# CITY OF ALBUQUERQUE

RE: **Parking Lot for 6<sup>th</sup> St/Fruit Ave**  
**6th St/Fruit Ave**  
**Grading and Drainage Plan**  
**Engineers Stamp Date 8/4/15 (J14D177)**

Based upon the information provided in your submittal received 8/4/15, this plan cannot be approved for Grading Permit or Paving Permit until the following comments are addressed.

ENGINEER'S SEAL  8/4/15 DAVID SOULE P.E. #14522	PARKING LOT FOR 6TH ST AND FRUIT AVE. LANDSCAPE PLAN		DRAWN BY DEM DATE 7-15-15 FILED IN LAND PLAN
	 Rio Grande Engineering 1008 CENTRAL AVENUE SUITE 301 ALBUQUERQUE, NM 87108 (505) 876-0666		SHEET # 3 of 3 JOB # XXXXX

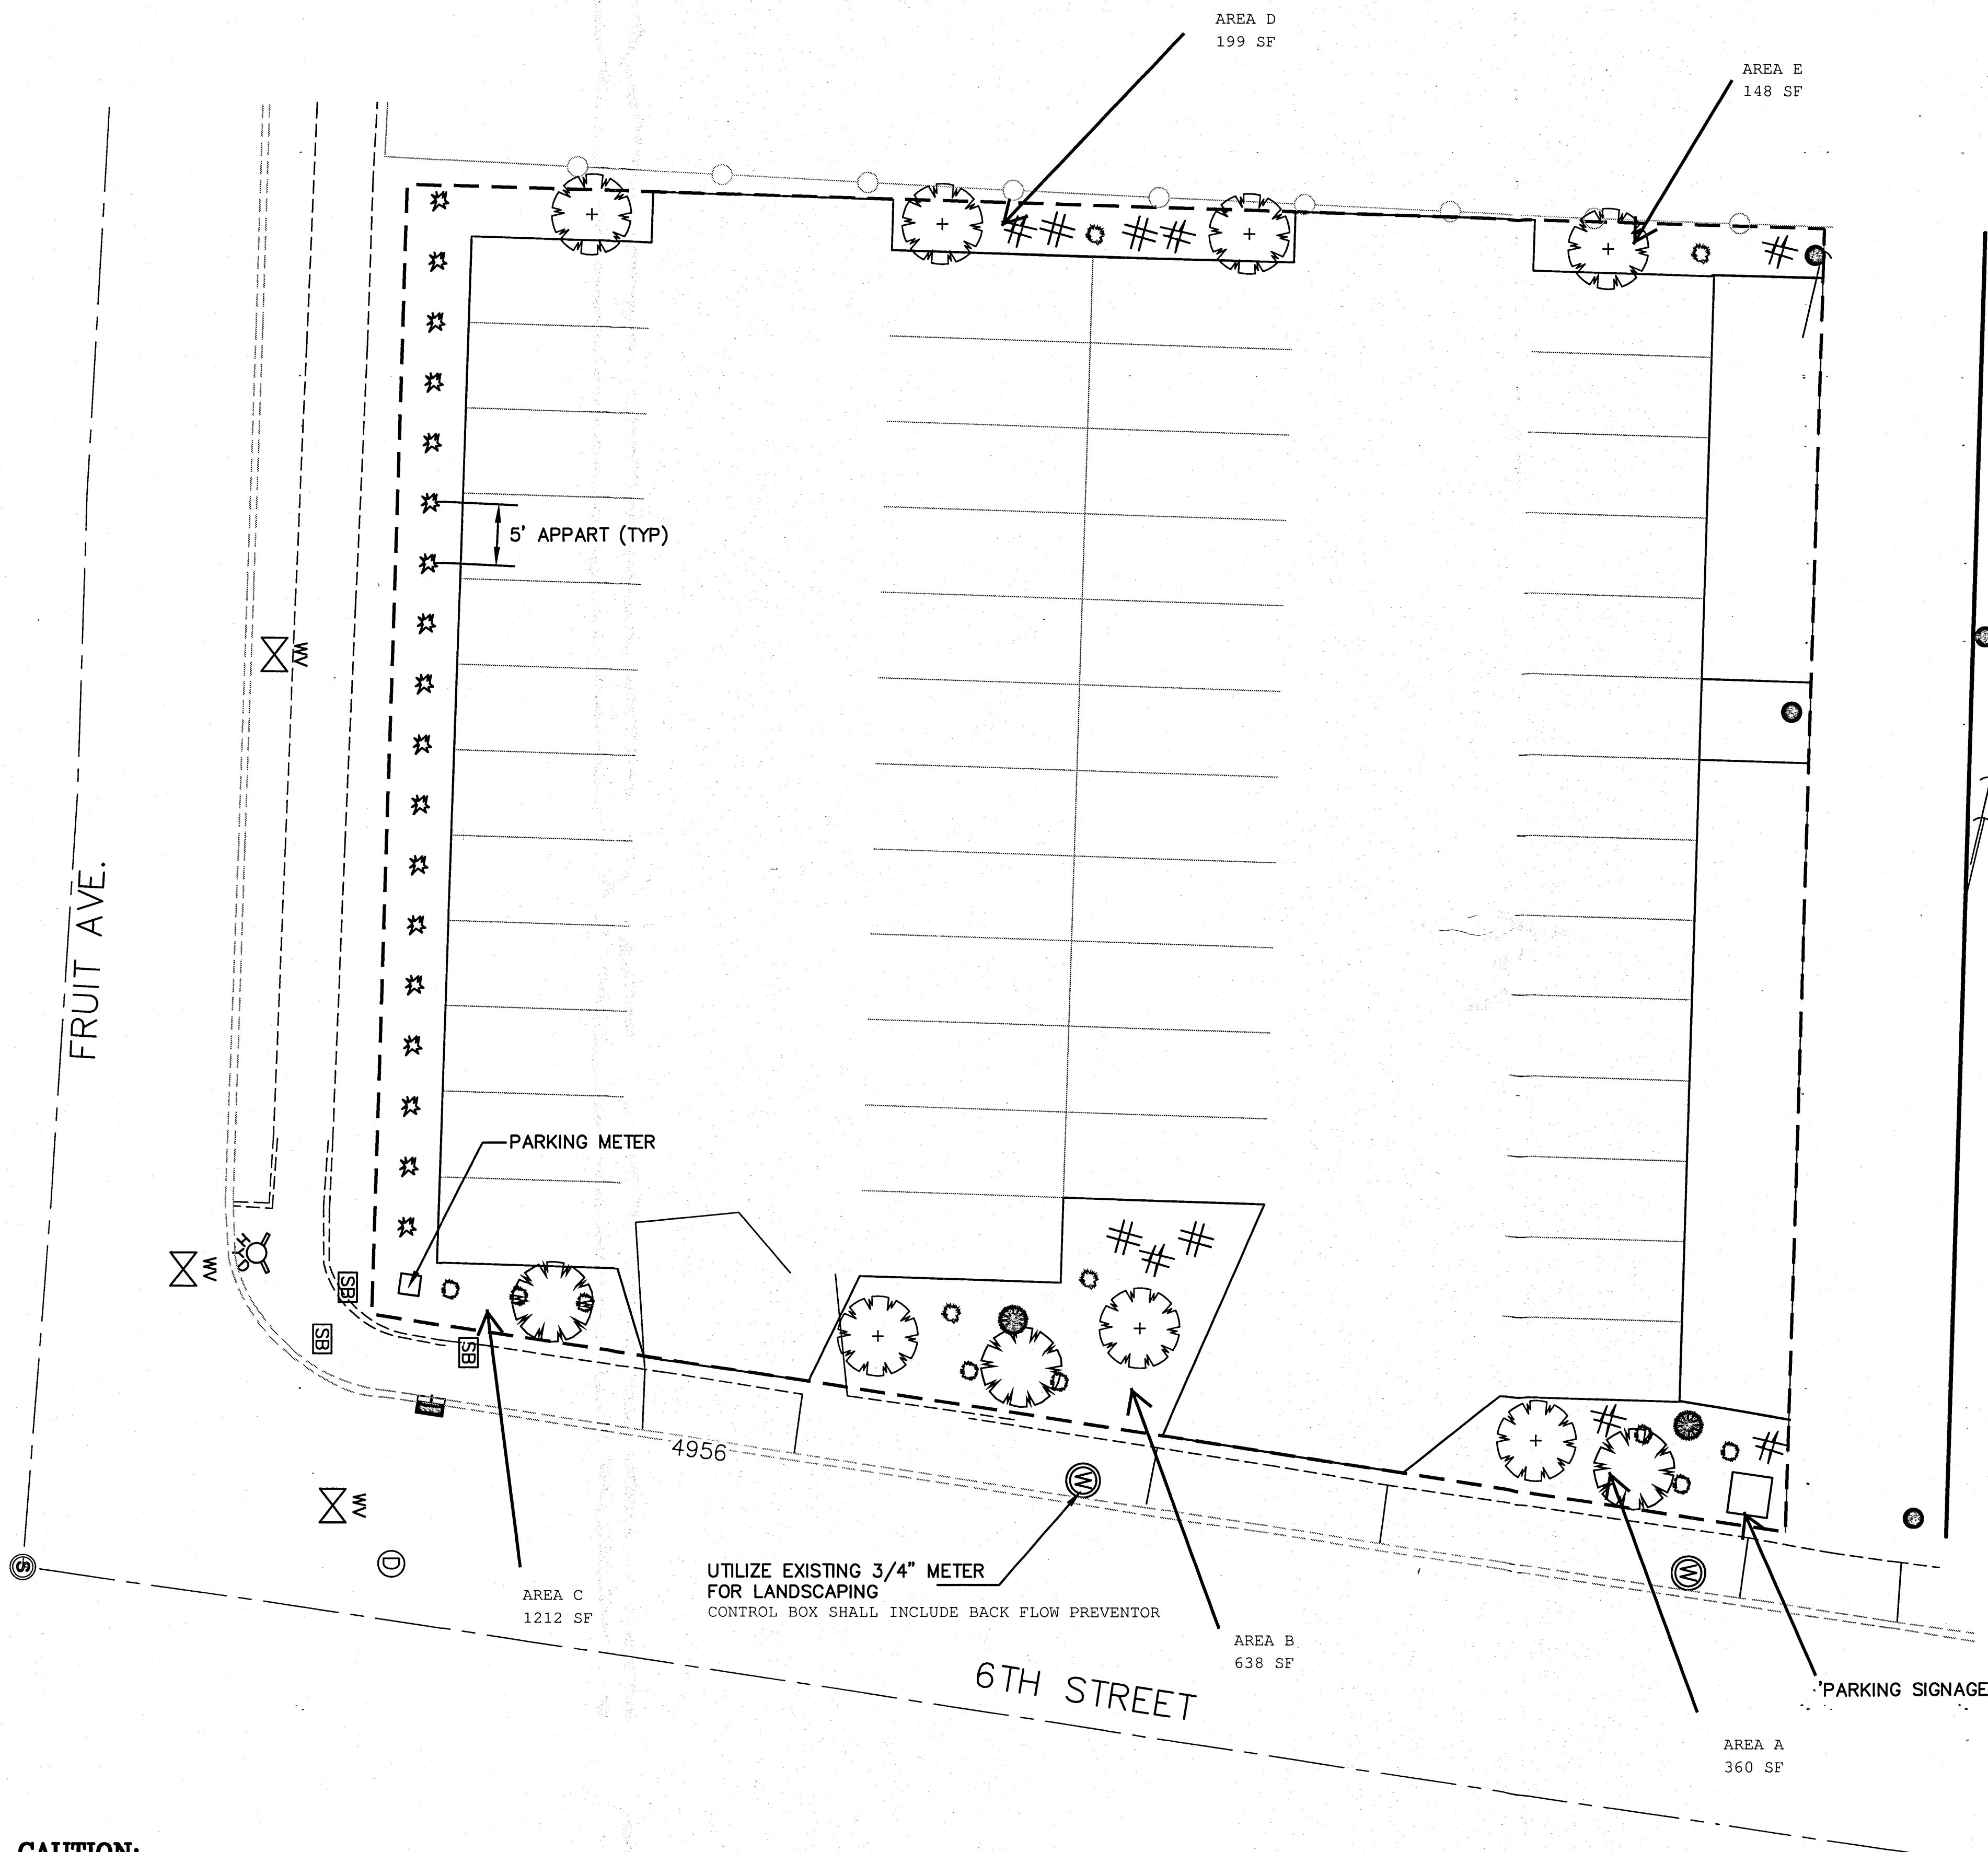
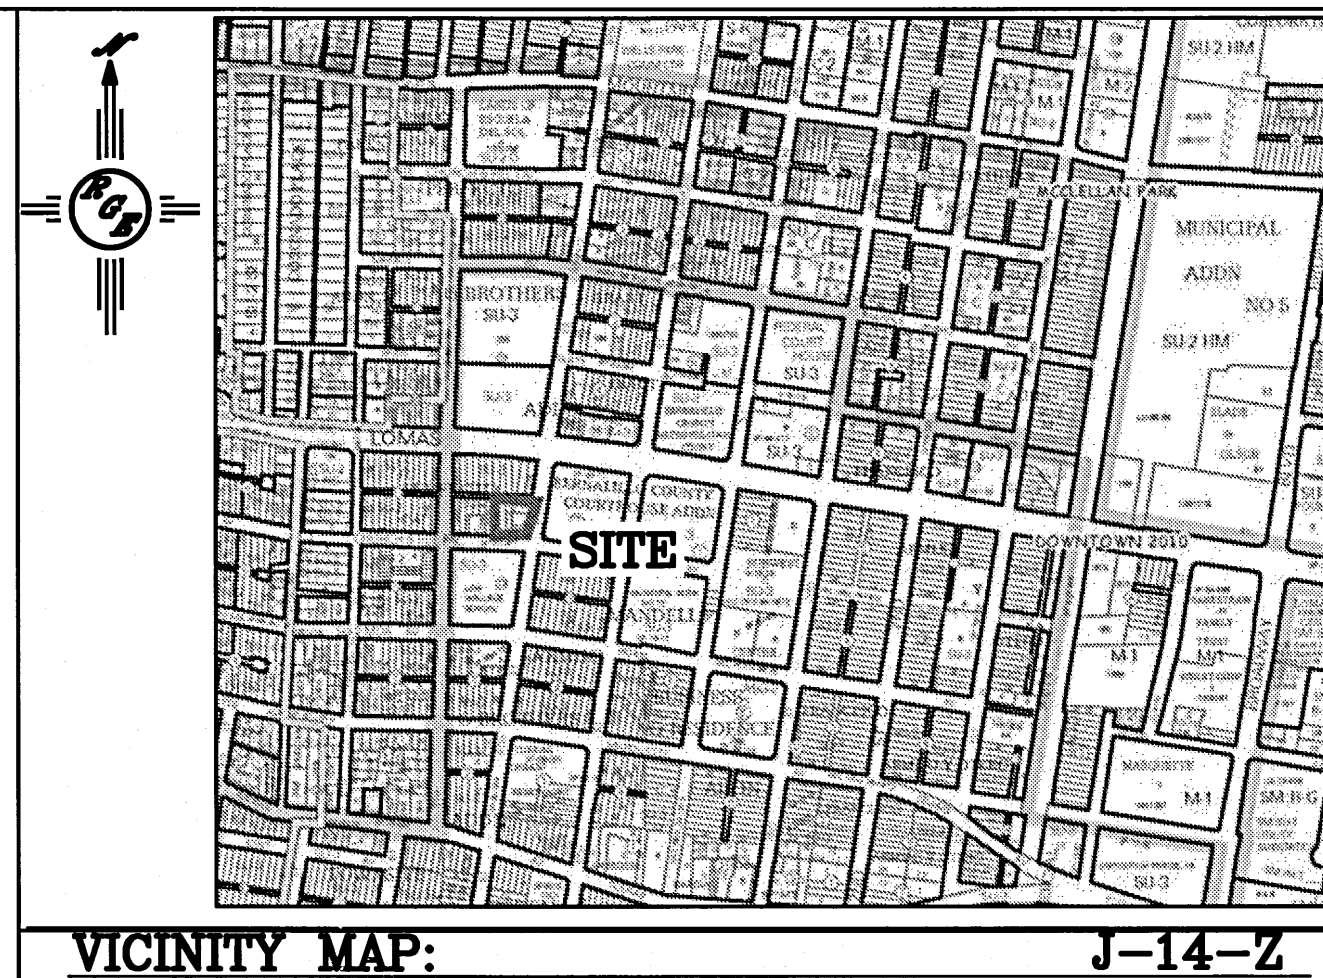
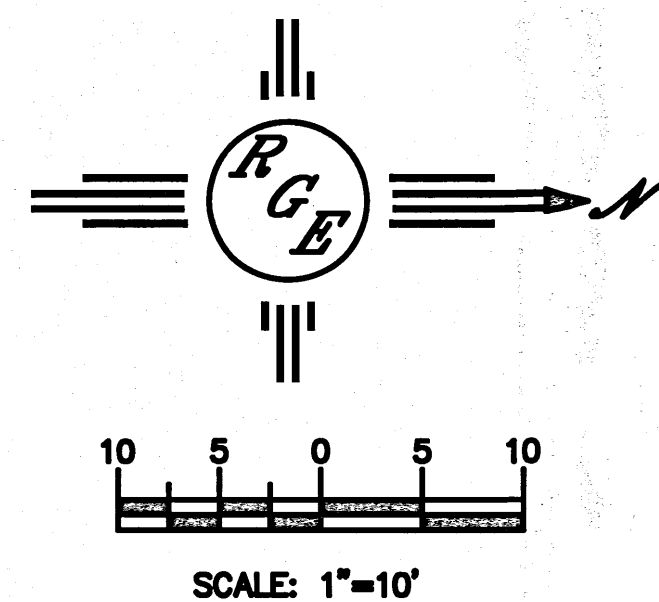
- Provide a larger font for the Drainage Calculation Sheet. ~~Not complete~~
- In the narrative a new home being built is mentioned. Where is the home located in this parking lot? ~~Not answered~~
- The first flush pond to the south shows a TOP = 4957.00 and a BOTTOM = 4056.00, I hope this is a typo, adjust accordingly. ~~Not answered~~
- The three ponds to the east have a TOP shown larger than the spot elevation provided next to the ponds, adjust accordingly. ✓
- Is the lot being paved, or kept as is? Are parking bumpers supplied? The alley will need to be paved. A TCL is required. ~~Not answered~~
- Provide the benchmark. ~~Not answered~~
- How will erosion, dirt, dust from the parking lot be kept out of the right of way (6<sup>th</sup> St.)? ~~Not answered~~

- Provide a larger font for the Drainage Calculation Sheet. **ADDED**
- In the narrative a new home being built is mentioned. Where is the home located in this parking lot? **CORRECTED**
- The first flush pond to the south shows a TOP = 4957.00 and a BOTTOM = 4056.00, I hope this is a typo, adjust accordingly. **CORRECTED**
- The three ponds to the east have a TOP shown larger than the spot elevation provided next to the ponds, adjust accordingly. **CORRECTED**
- Is the lot being paved, or kept as is? Are parking bumpers supplied? The alley will need to be paved. A TCL is required. **INCLUDED TCL**
- Provide the benchmark. **ADDED**
- How will erosion, dirt, dust from the parking lot be kept out of the right of way (6<sup>th</sup> St.)? **INCLUDED LANDSCAPE PLAN TO SHOW GRAVEL**
